**WELWYN HATFIELD BOROUGH COUNCIL
EXECUTIVE DIRECTOR - PLANNING, PUBLIC PROTECTION AND GOVERNANCE**

Application No: 6/2018/1967/LAWP
Location: Manor Cottage Vineyards Road Northaw Potters Bar EN6 4PQ
Proposal: Certificate of lawfulness for erection of outbuilding
Officer: Ms Lucy Hale

Recommendation: Refused

5 Site plan
1 : 400

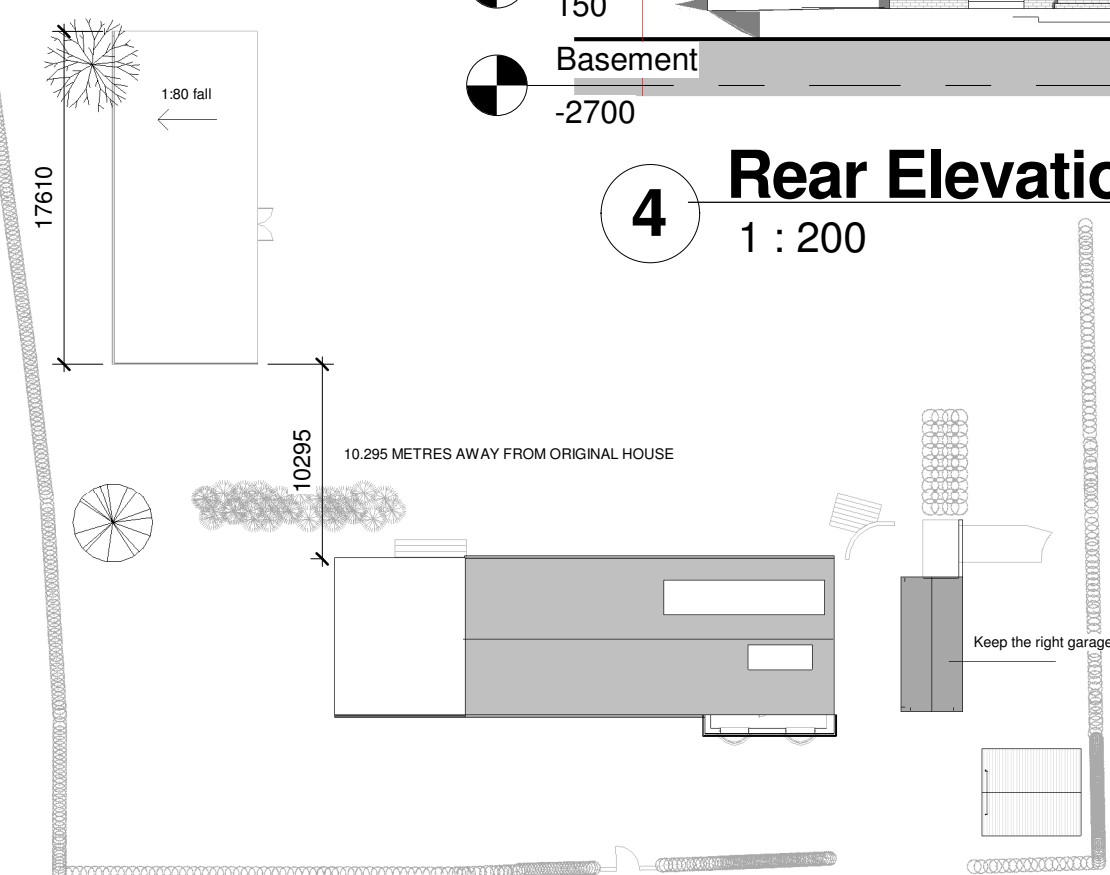
The application site consists of a detached chalet style bungalow on a large plot which according to the existing plans benefits from a detached garage to the front of the dwelling and detached double garage to the side. It is noted on the plans that one of these garages to the side of the dwelling would be removed.

The proposed outbuilding would be situated within the rear garden of the application site approximately 10 metres away from the application dwelling and would measure approximately 129 square metres. It should be noted that the application follows a previously refused application under

7 Outbuilding layout
1 : 200

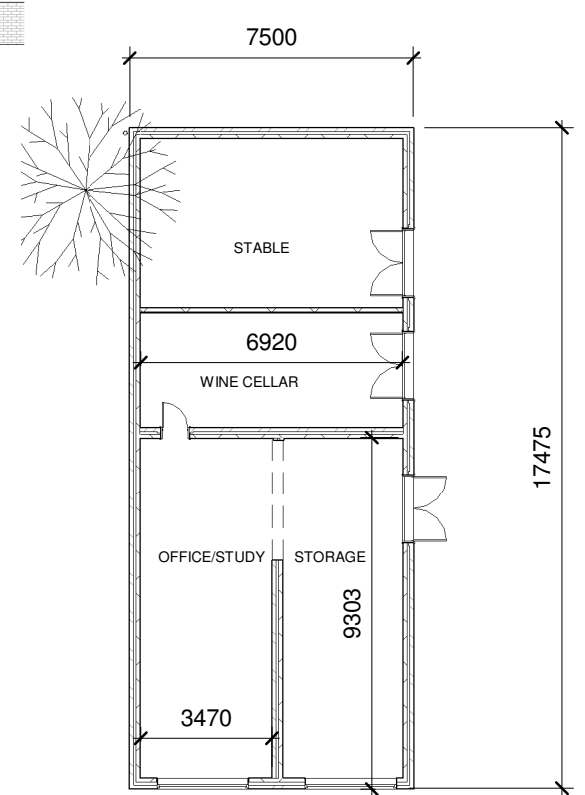
The outbuilding would accommodate an office/study, storage area, wine cellar and a stable. The proposed office/study would measure approximately 9.3 metres by 3.4 metres, the storage area would measure 9 metres by 3 metres, the wine cellar would measure 6.9 metres by 3 metres and the stable would measure 6.9 metres by 4.4 metres.

Whilst the proposed uses of the outbuilding which includes an office/study, wine cellar and stable, are considered to be uses that may be incidental to the main dwelling under Class E, the key test is whether the proposed outbuilding is reasonable for its intended purpose. The proposed size of the outbuilding is still very large for its intended use and no details, other than an annotation on the drawing labelling the use of each room has been provided.

Furthermore, it is noted that the annotations for the intended uses of the outbuilding have changed from the previous applications submitted under references 6/2018/1107/LAWP, 6/2018/0297/LAWP and 6/2017/2664/LAWP. For example, an office/study has now been proposed as well as a stable. No justification has been submitted to demonstrate why the intended use are required, and of such size for an office or study is required. In regard to the stable, no details and justification have been submitted for its intended use. Furthermore, the elevations submitted do not translate the intended use of a stable by means of access and ventilation. Details have not been provided to outline why the size of the stable is required.

On the evidence available, the LPA is not satisfied as a matter of fact and degree that the totality of the proposed building is genuinely and reasonably required. Without an explanation of the intended uses so as to make clear the justification of the size and scale of the building, it cannot be ascertained that the outbuilding is reasonably required for purposes incidental to the enjoyment of the dwelling. Furthermore, the introduction of alternative intended uses to that previously proposed in the last three applications, begs the question of the genuine need of the outbuilding for the site.
